**Re: Hilltop Farm, Redbrook Road, Barnsley**

I refer to our recent correspondence and, in particular, to your e-mail of 25 March with comments that have been raised by the Tree and Highways Officers.

I am attaching for your attention three copies of our revised layout drawing which illustrate the following adjustments.

SITE LAYOUT PLAN

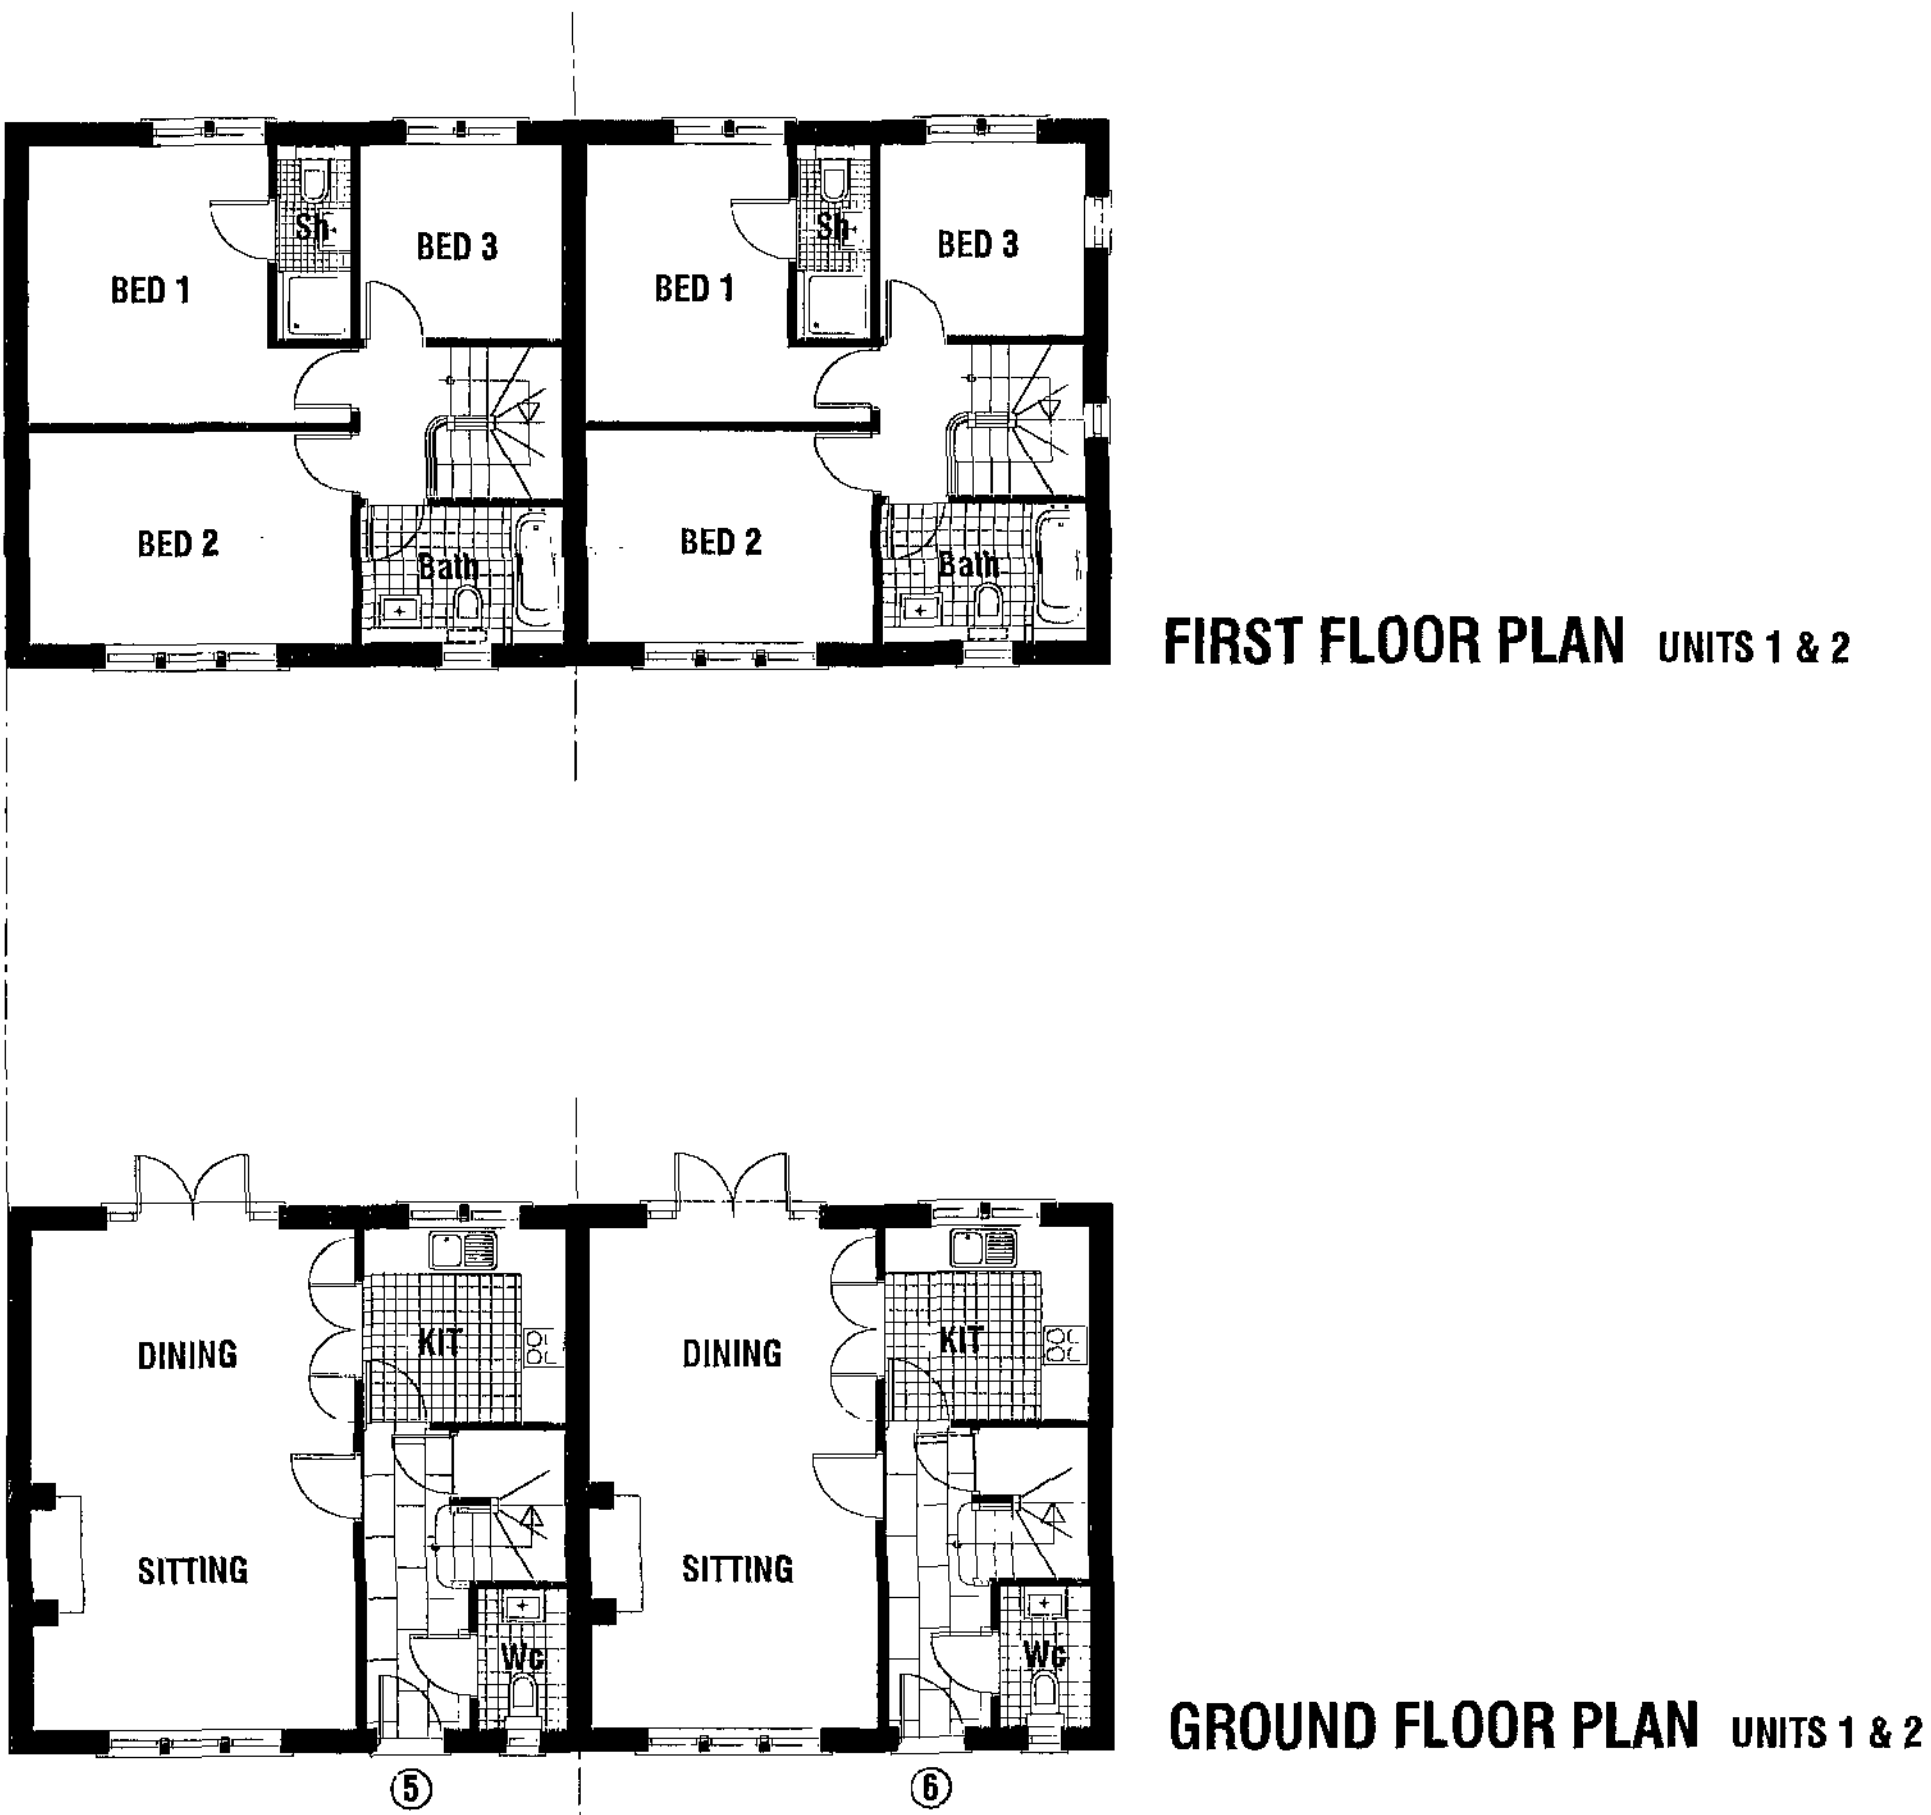
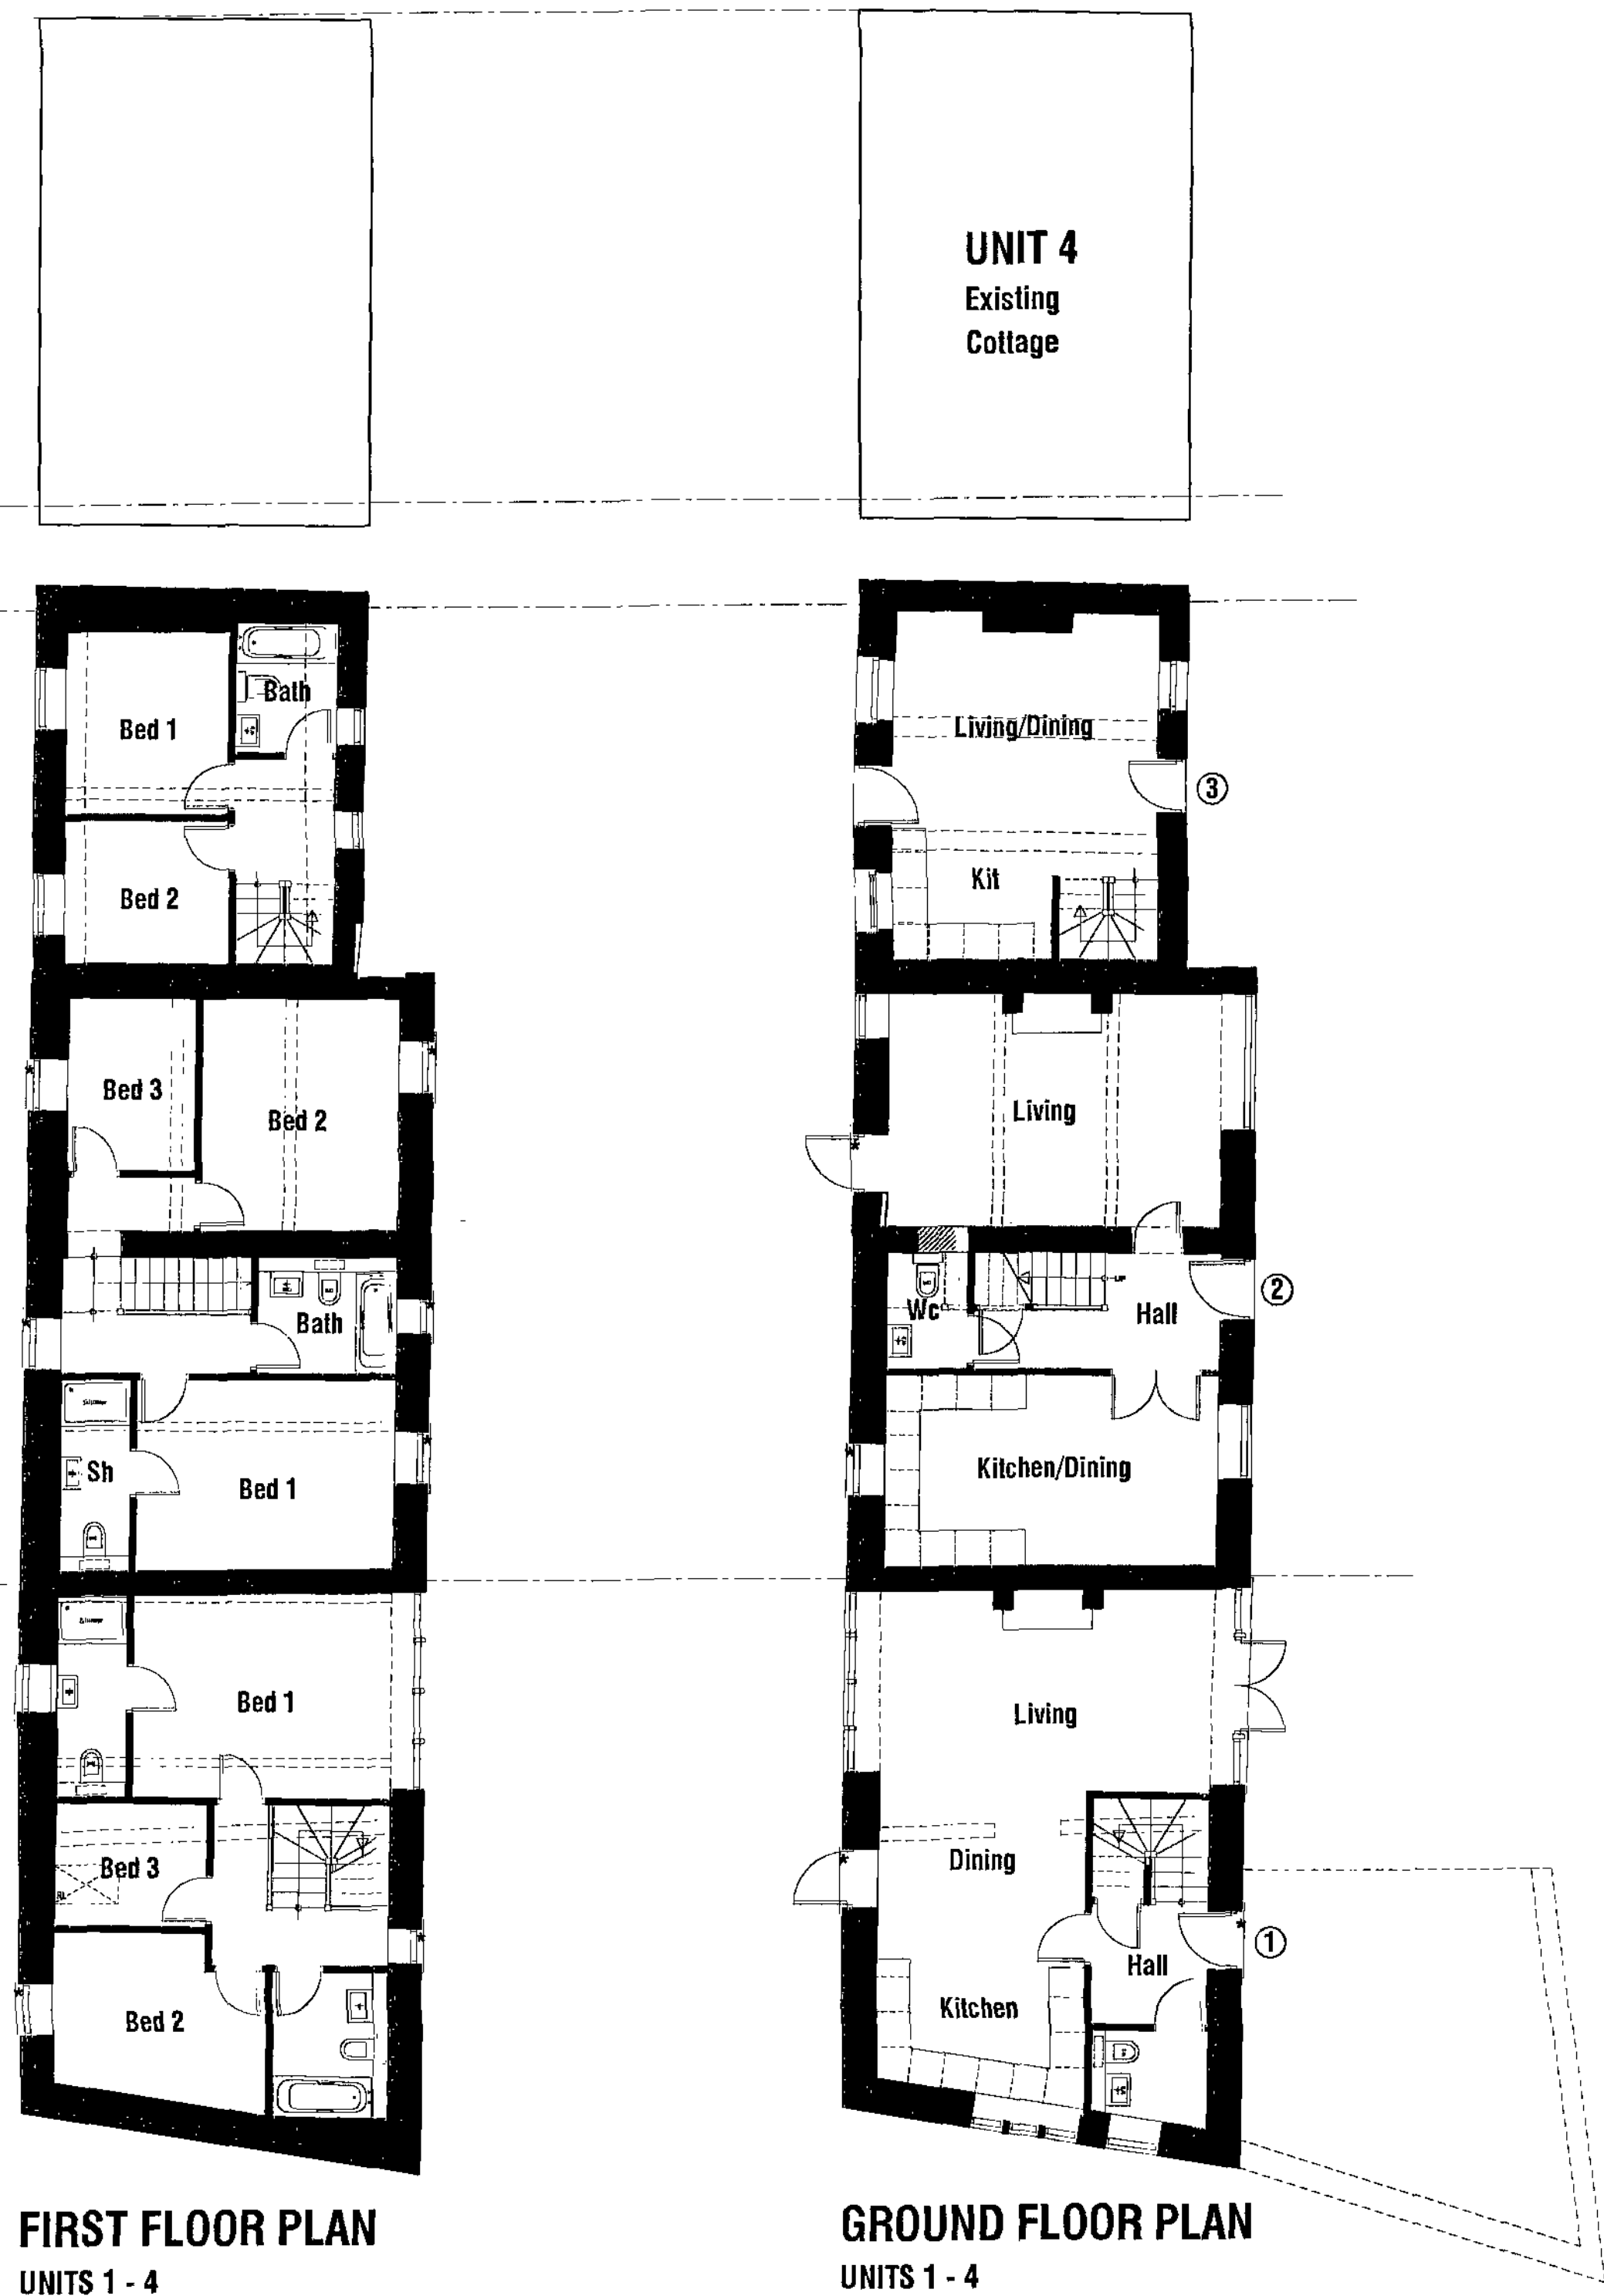
*Highways*

*Trees*

I note the comments raised by the Tree Officer with regard to a communal garden, excess hard surfacing and the desire to have fewer parking spaces. I would make the following points:

We have revised the new access carriageway which is now shown at 4.5m wide with 0.6m paved strips to both sides.

I can confirm that the walls adjoining the entrance will be at a maximum of 1.05m high above pavement level.

I can confirm that the junction of the access onto Redbrook Road has been revised to take the form of a dropped crossing and not the radius crossing previously shown.

- The parking and hard surfaced areas currently proposed will have less impact upon the retained ash tree than is the case with the existing condition. The two parking spaces numbered P5 are currently occupied by a three storey stone building. Any impact upon the retained tree will be dramatically reduced by the removal of this structure and adjoining single storey farm buildings.

- 2 No parking spaces per dwelling are required for Units Nos 1, 2, 5 and 6. These spaces have to be provided within the communal courtyard space whilst still retaining turning/manoeuvring room for an emergency or delivery vehicle, maintaining access to the separate parking courtyard which serves No 32 and the new parking spaces in respect of Units 3 and 4, and retains a pedestrian right of access through to the proposed residential development to the rear of the site. No alternative layout is possible that achieves all these aims.

- I have amended our drawing to illustrate the parking spaces Nos P5 and P6 surfaced with a free-draining gravel finish rather than block paving as previously shown.

- By reducing the overall dimensions of the road, omitting footpaths and allowing for maximum 600mm strips to both sides, we have increased the area of greenery surrounding the retained ash tree.

- The boundary wall to the gardens of Plots Nos 5 and 6 has been replaced with a hedge.
- The practical difficulties of parking immediately adjoining the existing ash tree cannot be avoided and falling debris (leaves, sap etc) will have to be accepted by the owners of the adjoining houses.
